STATE OF WASHINGTON
DEPARTMENT OF ECOLOGY

June 2, 2008

Thank you for the opportunity to comment during the optional determination of nonsignificance process for the F & G Performance Based Cluster Plat, proposed by Cool Water, LLC and Fortune Creek, LLC [LP-08-09]. We have reviewed the documents and have the following comments.

**F & G  
PERFORMANCE BASED CLUSTER PLAT**  
PTN. S 1/2 OF SECTION 7, T. 19N., R. 15E., WM.  
KITITAS COUNTY, STATE OF WASHINGTON

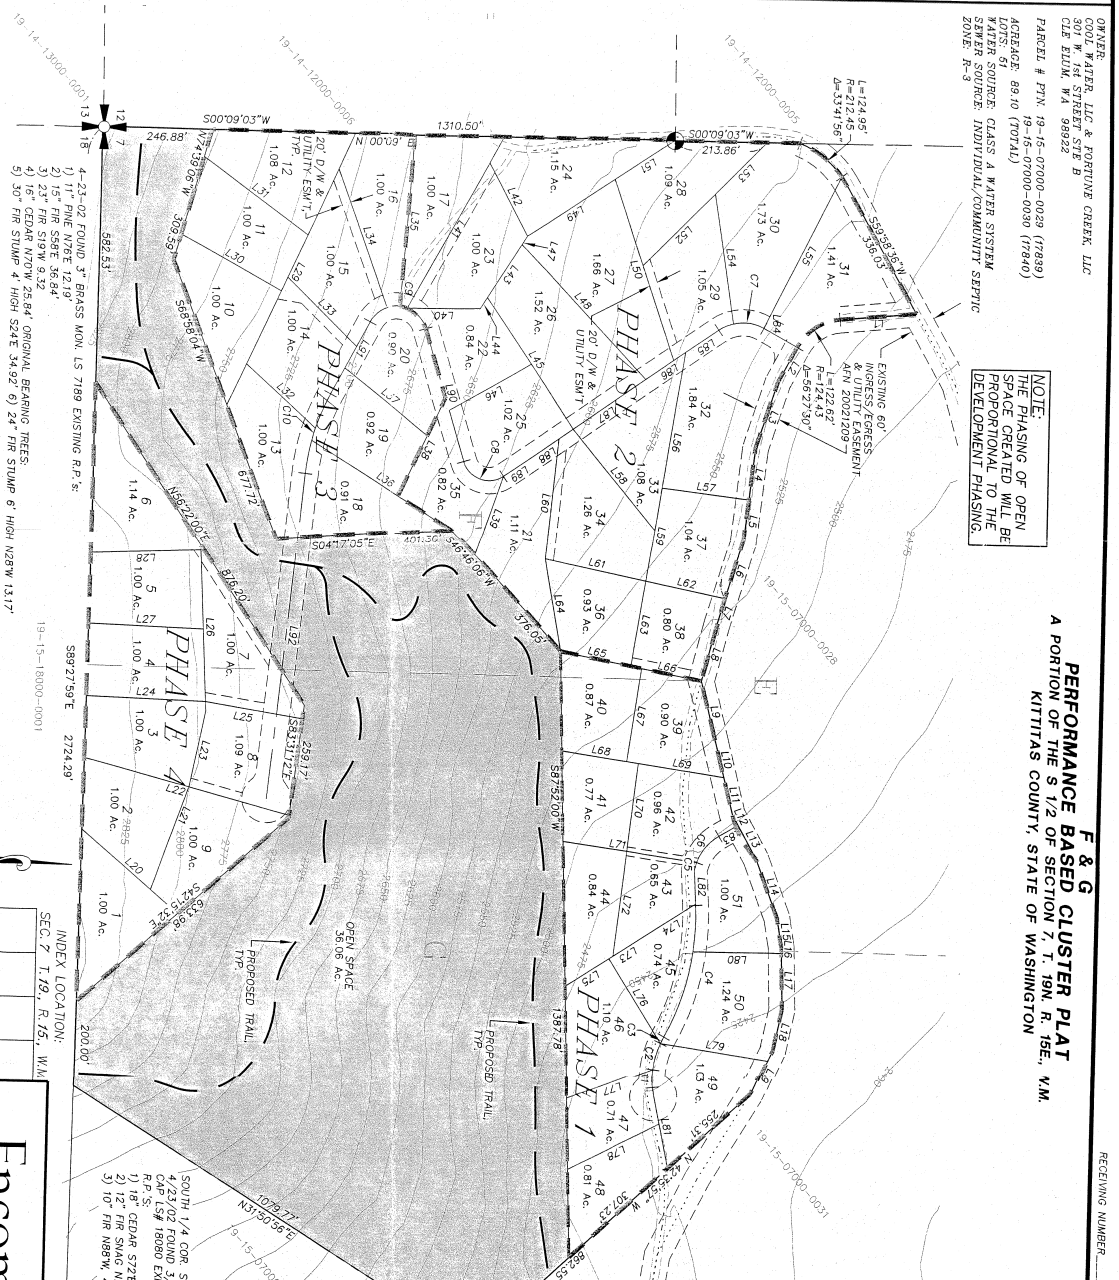
It appears from aerial photo review that there may be wetlands associated with the stream corridors on site. There may be wetlands in the adjoining property to the south as well. The presence of cedar trees as indicated in the checklist are often found in wetland areas. Both streams and wetlands are considered to be critical areas. If wetlands or streams are present on site, lot lines should be drawn to assure that each approved lot will not need a variance from Critical Areas Ordinance (CAO) standards/buffers in order to be developed. Residential lots are considered to be high intensity development with respect to determining how big buffers should be to protect their functions. Therefore, maximum buffers sizes based on best available science should be applied between high intensity uses and adjacent wetlands. Also, streams should not be re-routed to accommodate the placement of lots or roads.
